## ATTACHMENT 1 – Department’s Response to Submission review comments

In order to finalise the Department’s assessment, additional information is required including but not limited to the following:

LRGID

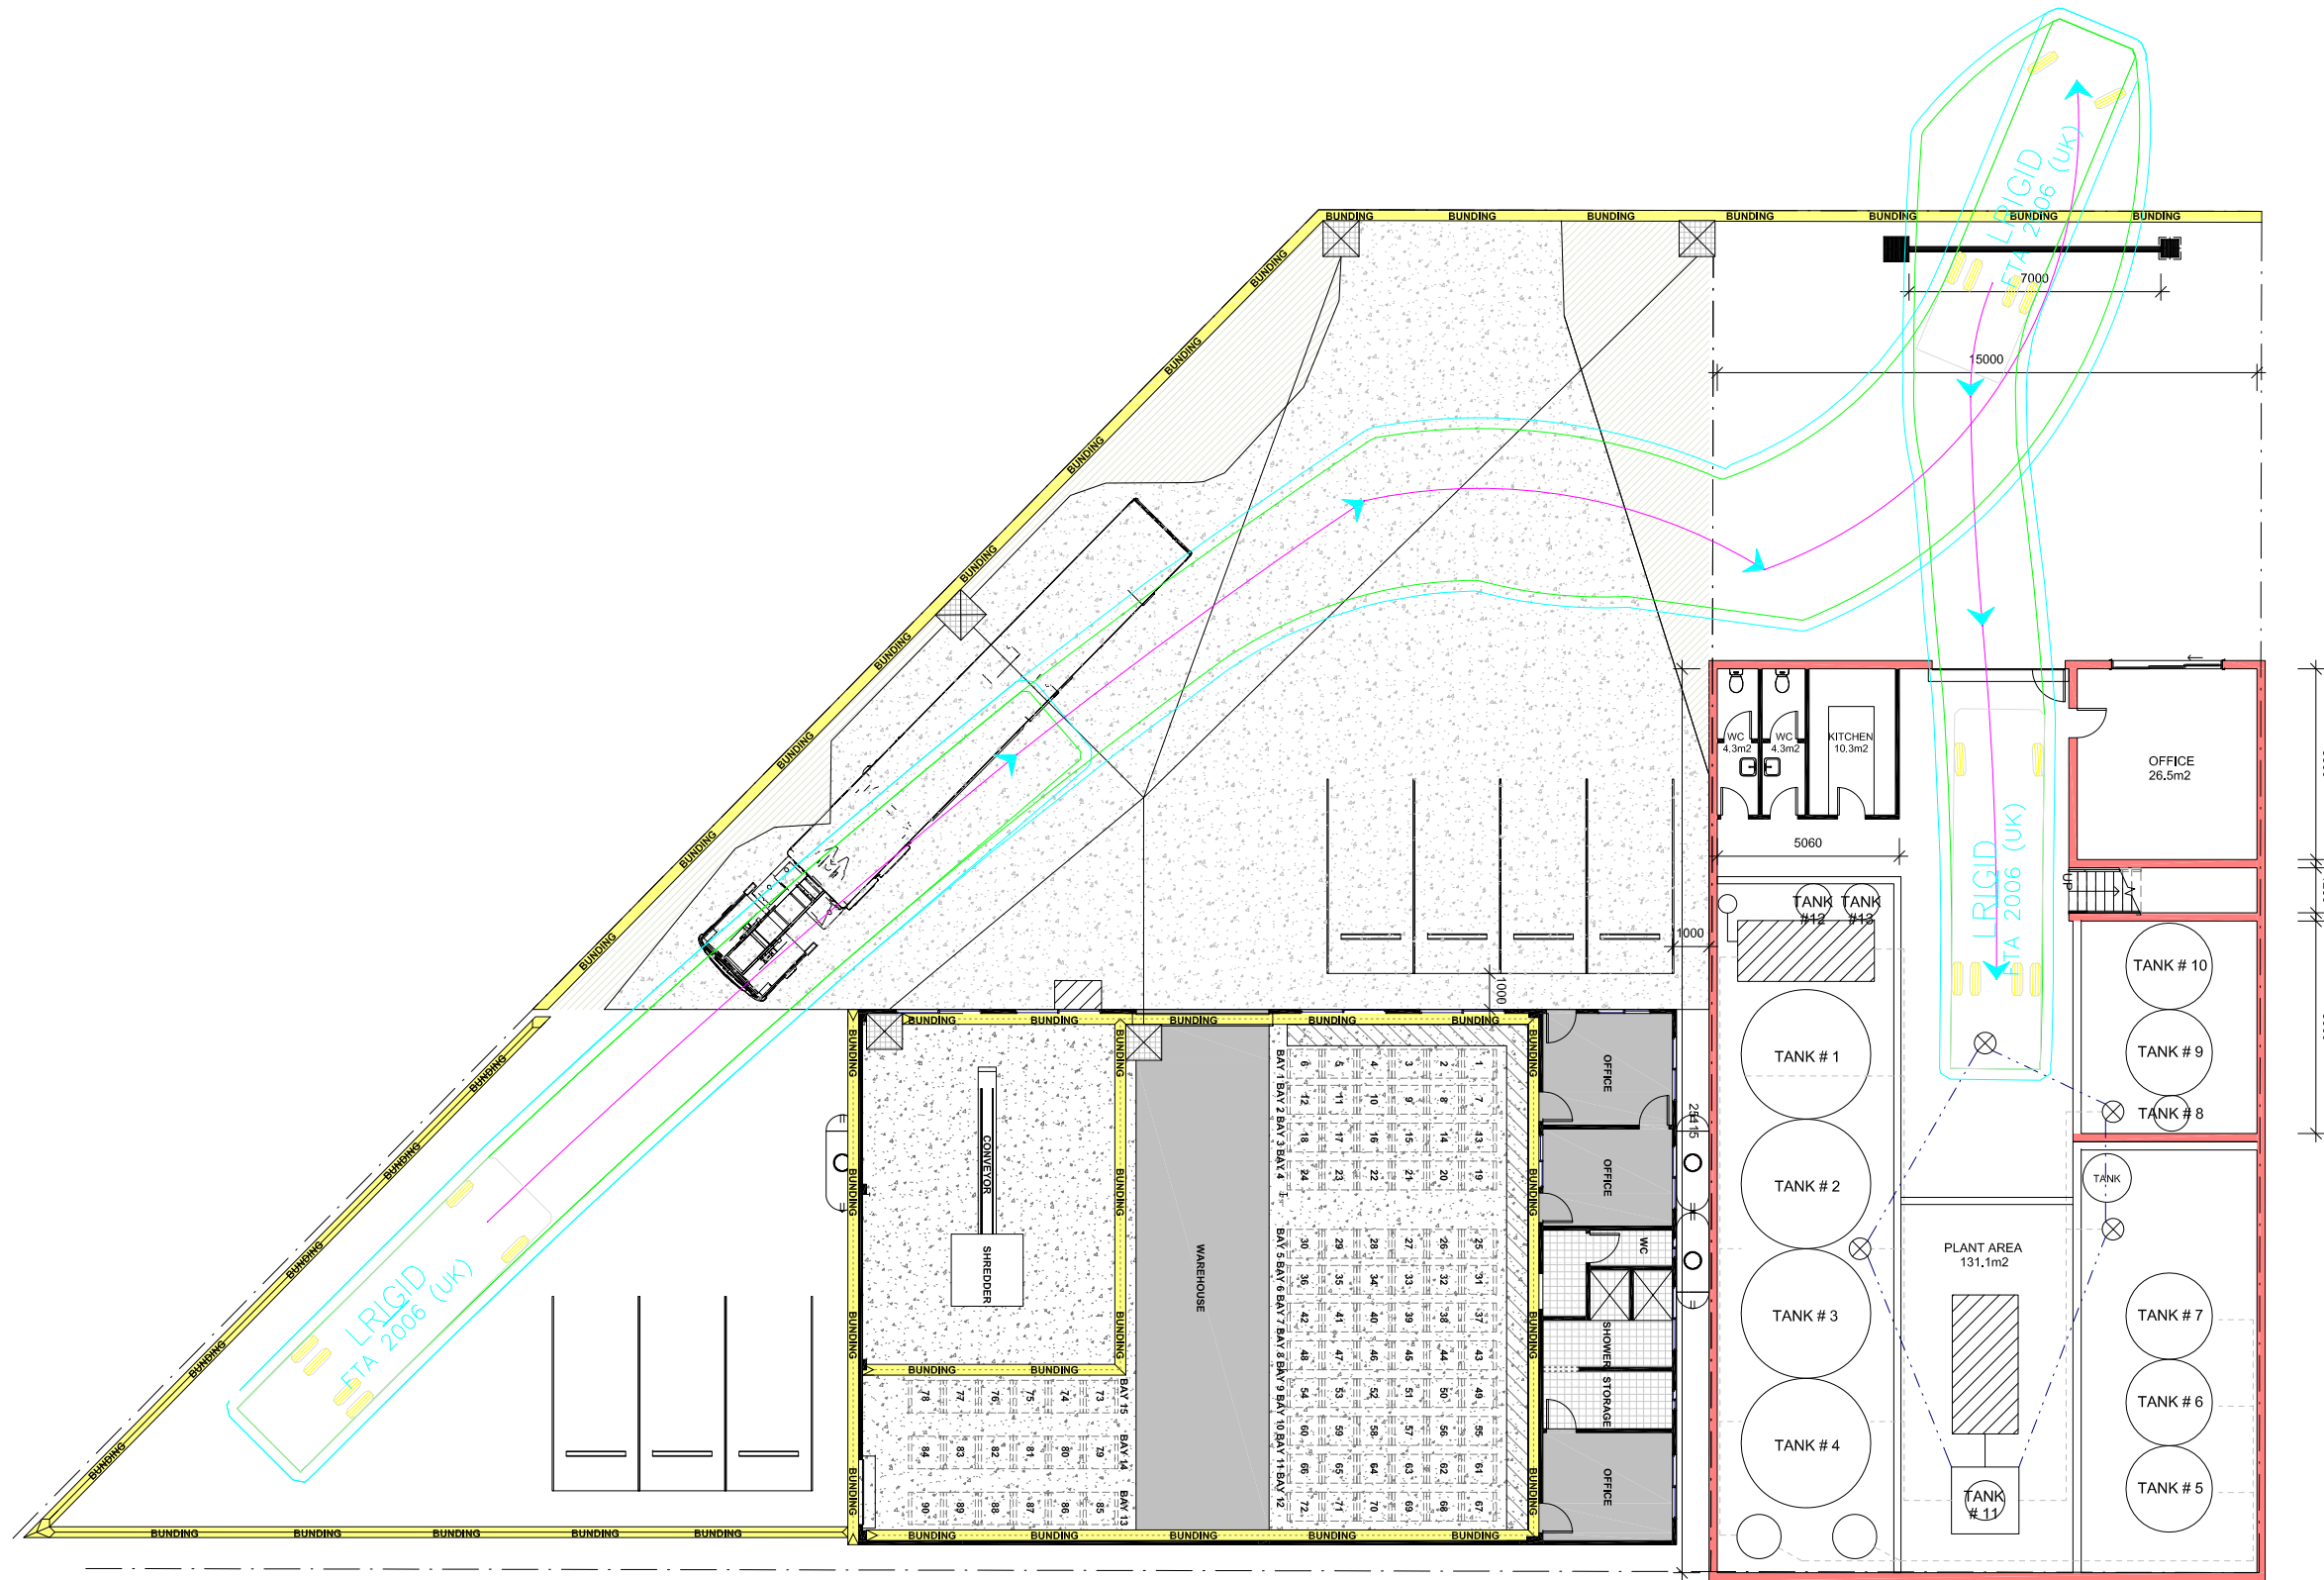
- The vehicle and trucks registration provided in Attachment 8 of the revised EIS lists a site vehicle which is 11.5 metres (m) in length, however swept paths provided have only been provided for 10 m trucks. For consideration of potential future delivery vehicles and to be consistent with Australian Standards, swept paths should be provided for 12.5 m trucks. Please update.

- The Department has previously requested for the Applicant to further consult with Council to resolve truck manoeuvrability issues at the site. The RtS does not provide sufficient evidence to indicate that internal swept path movements have been satisfactorily resolved with Council. Trucks are still required to be undertake a four-point turn and reverse into Council land which has been identified as being unsatisfactory by Council, whereby manoeuvring should be limited to a 3-point turn into the site. Please address.

- Council have further identified safety risk concerns associated with reverse manoeuvring on Council’s land. Vehicles are required to enter and leave the site in a forward direction. The Applicant has not resolved this issue.

- Update the swept path drawing to clearly demonstrate vehicle movements entering and leaving both 14 and 16 Kiara Crescent.

- Council have identified that they would not support the proposed driveway widening and that the use of the driveway should be for access only, and not for manoeuvring. It is further noted that the proposed widening of the driveway at 16 Kiara Crescent to allow for greater room for vehicle turning also contradicts with Council's request for all vehicles to manoeuvre within the site itself. Please address.
